Subject: A/5/20/PL

*The Tree House Honey Lane Angmering BN16 4AB
studio apartments for holiday accommodation for artists*

Conversion of the Flint Barn & Garage Barn into 2 No.

drawing
Flint Barn as Proposed
Floor Plan, Roof Plan, Elevations
And Typical Cross Section

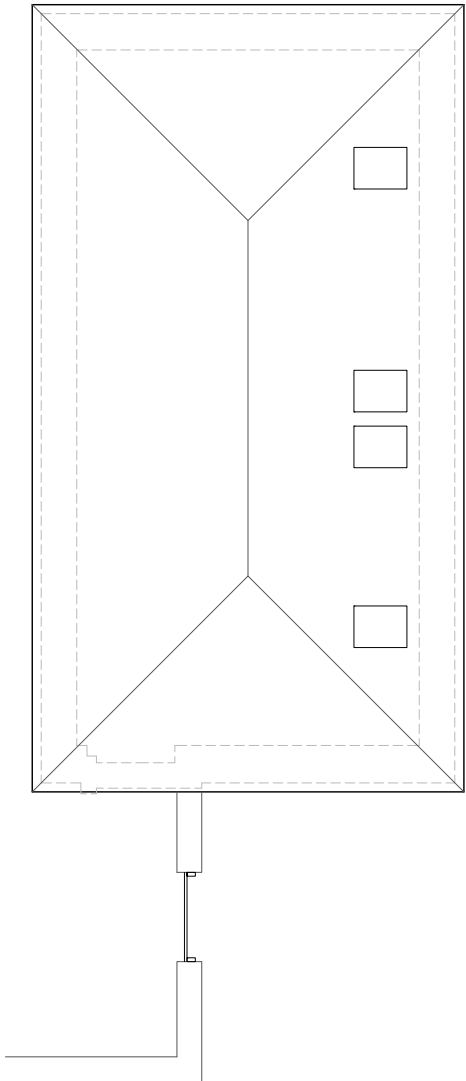
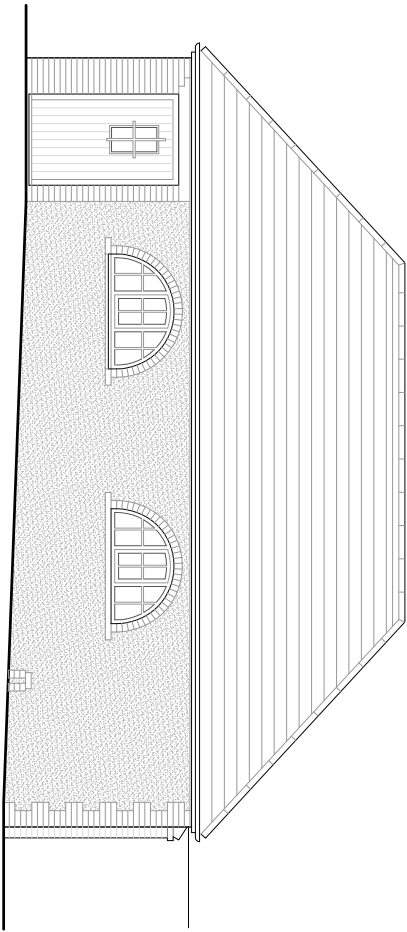
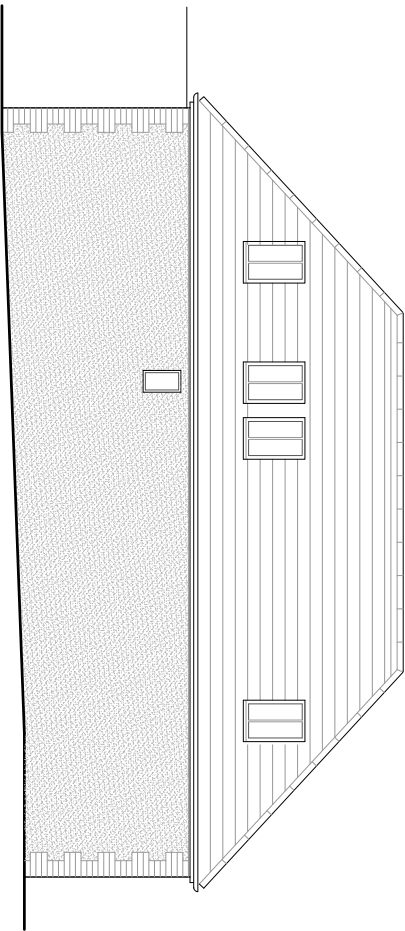
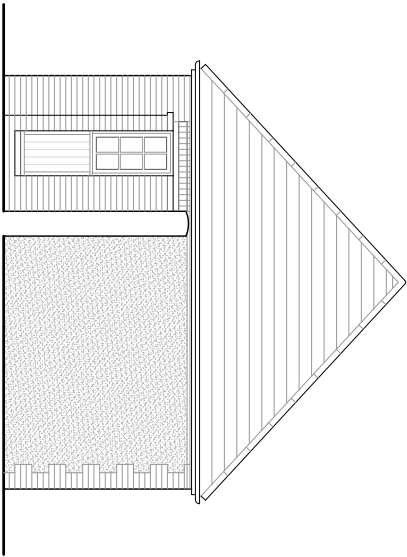
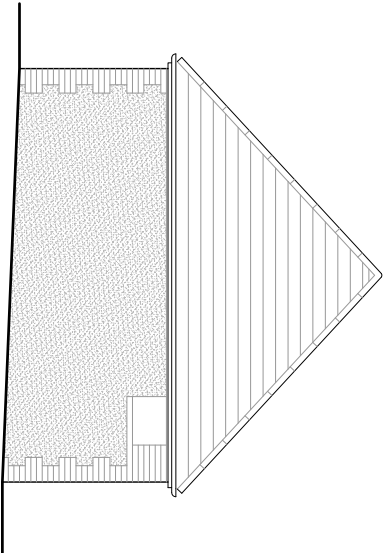
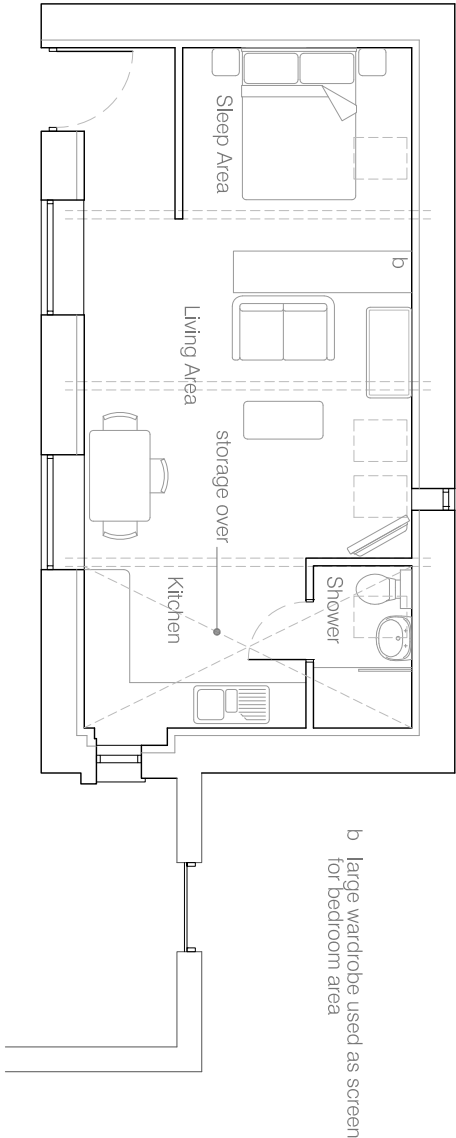
The works to the interior of the buildings seem to reflect the existing open character of the former agricultural spaces in that very few new partitions are proposed. Such a proposal shows a clear understanding of what makes these buildings special.

It is not clear how much of the existing joinery will remain or if it will be replaced. It is therefore recommended that, if they are to be replaced, that details of all new joinery should be provided to the LPA by way of condition. This will ensure that it reflects the character of the building.
